DORAN DRIVE
PRECINCT
(SSD-15882721)

RESPONSE TO SUBMISSIONS
REPORT

DEICORP PROJECTS
(SHOWGROUND) PTY LTD

April 2022

STORMWATER DRAINAGE
PLAN

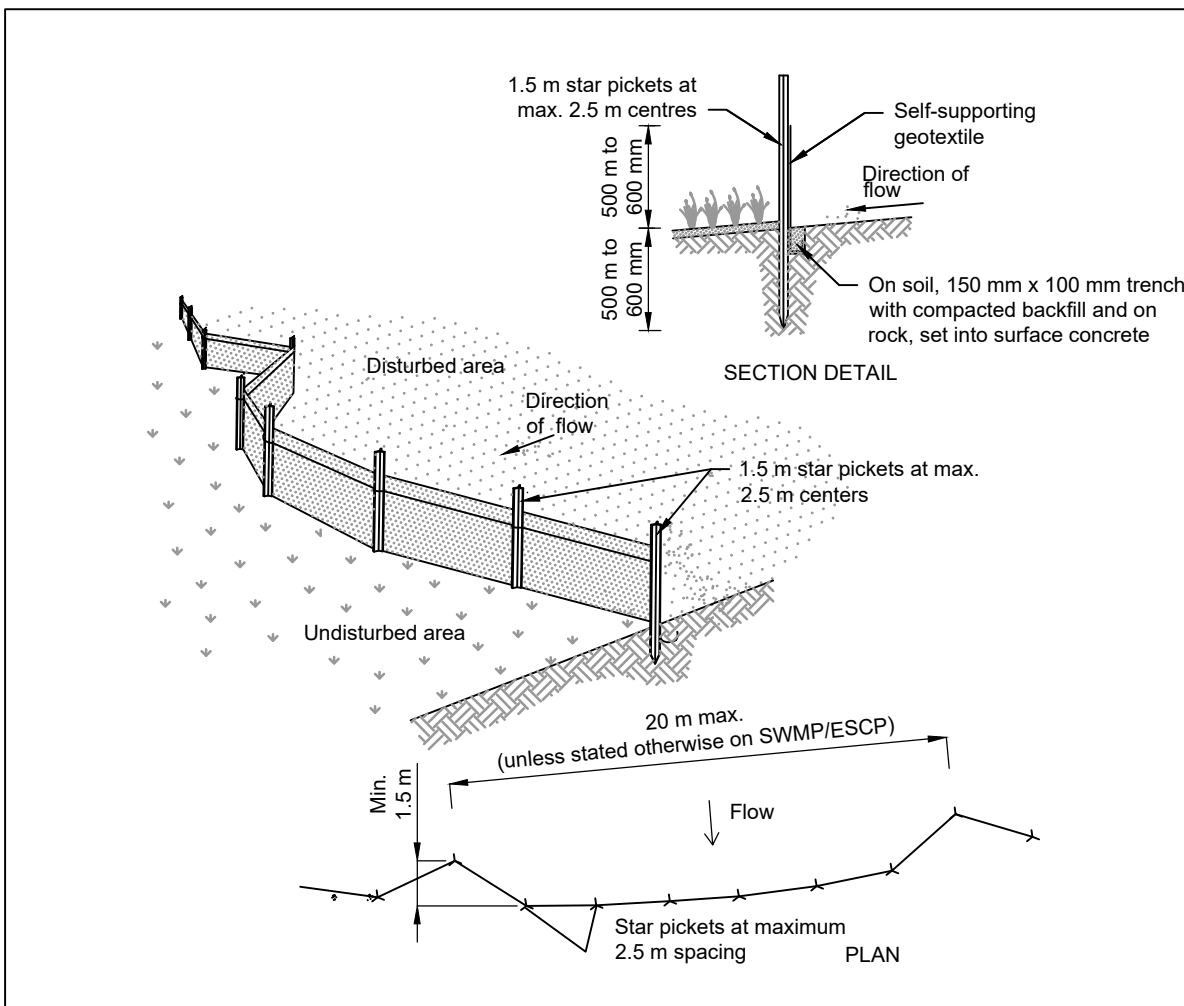
1. Stormwater comments		
<p>1.1</p> <p>The capacity of the stormwater system into which stormwater from the development discharges into must be checked and analysed. Please note that the check/analysis shall be carried out to the legal point of discharge to ensure that the street pits will not be surcharged during minor events up to the 10 years ARI storm event. Therefore, the Rainfall Intensities shall be updated and consistent with the section 4.10 Council's Design Guidelines Subdivisions/ Developments. Similarly, the duration of the analysis shall be extended to 72 hours. Also, the overflow depth for major storm event shall be Max 200mm not 300mm.</p>	<p>Aecom Civil Engineer</p> <p>The stormwater comparison conducted for the proposed development includes the existing drainage network surrounding the lot, down to the network on De Clambe Drive which ultimately discharges to a constructed swale and precinct basin.</p> <p>The post-development model was run for the 20%, 10% and 1% AEP storms, for all durations up to and including 72 hours.</p> <p>There was no pit surcharge from the post-development model for either the 20% or 10% AEP storm events.</p> <p>As per section 4.10 of Council's Design Guidelines Subdivisions/Developments, stormwater analysis has been carried out with the latest BOM data (IFD 2016) utilizing the AR&R19 methodology for ILSAX model within the software DRAINS.</p> <p>The proposed development does not contribute to overland flow within the roads for major storm events (1% AEP) i.e., there is no increase in overflow depth due to the development.</p> <p>The DRAINS model for the post-development scenario is provided to Council for review along with extracts of the inputs and output.</p>	Appendix 11
